TO: Genevieve Seed EMAIL: genevieve.seed@planning.nsw.gov.au
ORGANISATION: Department of Planning & Environment DATE: 22 January 2016
COPY: Gales-Kingscliff Pty Ltd REFERENCE: 617
Tweed Shire Council
NO. OF PAGES (including attachments): 5
SUBJECT: Cudgen Lakes Sand Quarry – Response to Council Comments

Figure 4: Distance to approved subdivision and Residence A

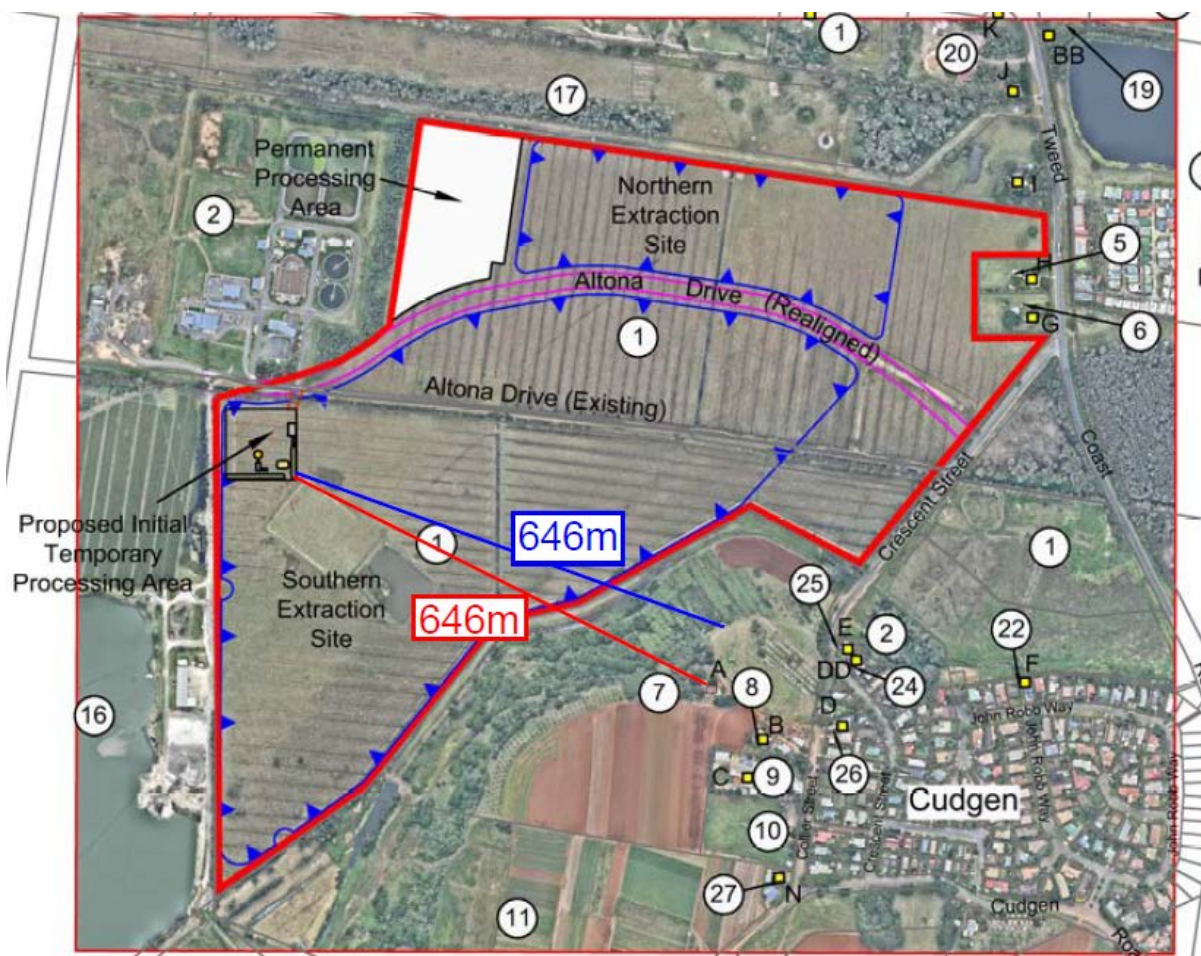
It is noted that the noise assessment for the Initial Processing Area considers impacts to Residence A which is located approximately the same distance as the closest subdivided block within the approved subdivision (see attached marked up plan). Therefore Residence A is representative of the adjacent subdivision. Given it was assessed that compliance would be achieved, no further assessment is considered necessary. Similarly, the air

Figure 5: Alternative office locations

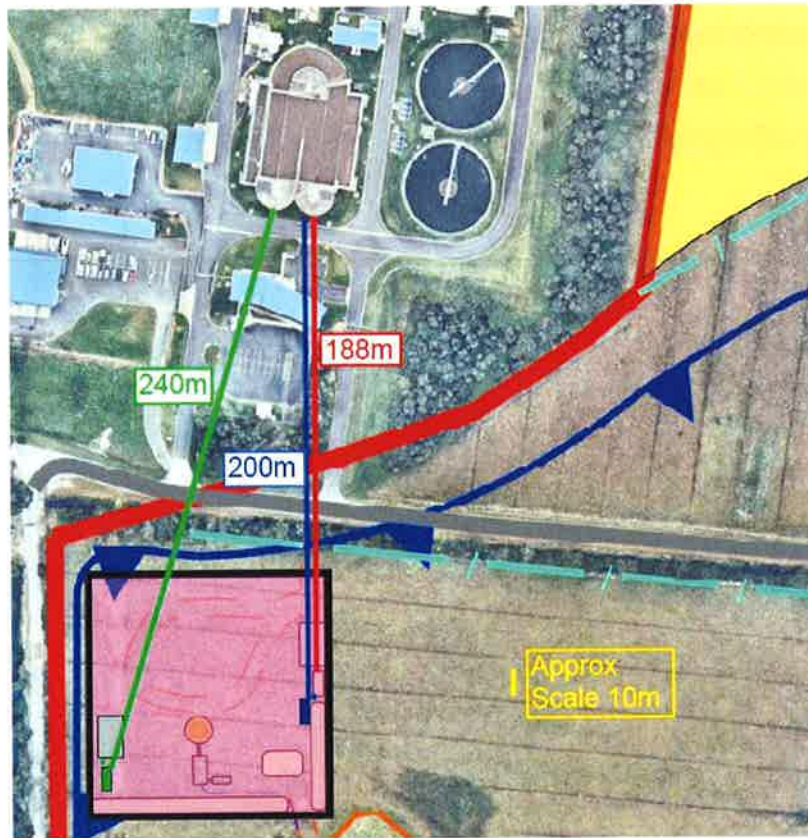
Please see attached a marked up plan showing our measurements of the existing office location and two alternative locations. As can be seen, it would be possible to maintain the office outside the 200m buffer zone on either the eastern or western side of the Initial Processing Area. Gales therefore has no objection to requiring that the Initial Processing Area office meet the 200m buffer zone and ventilation requirements of the Development Control Plan.
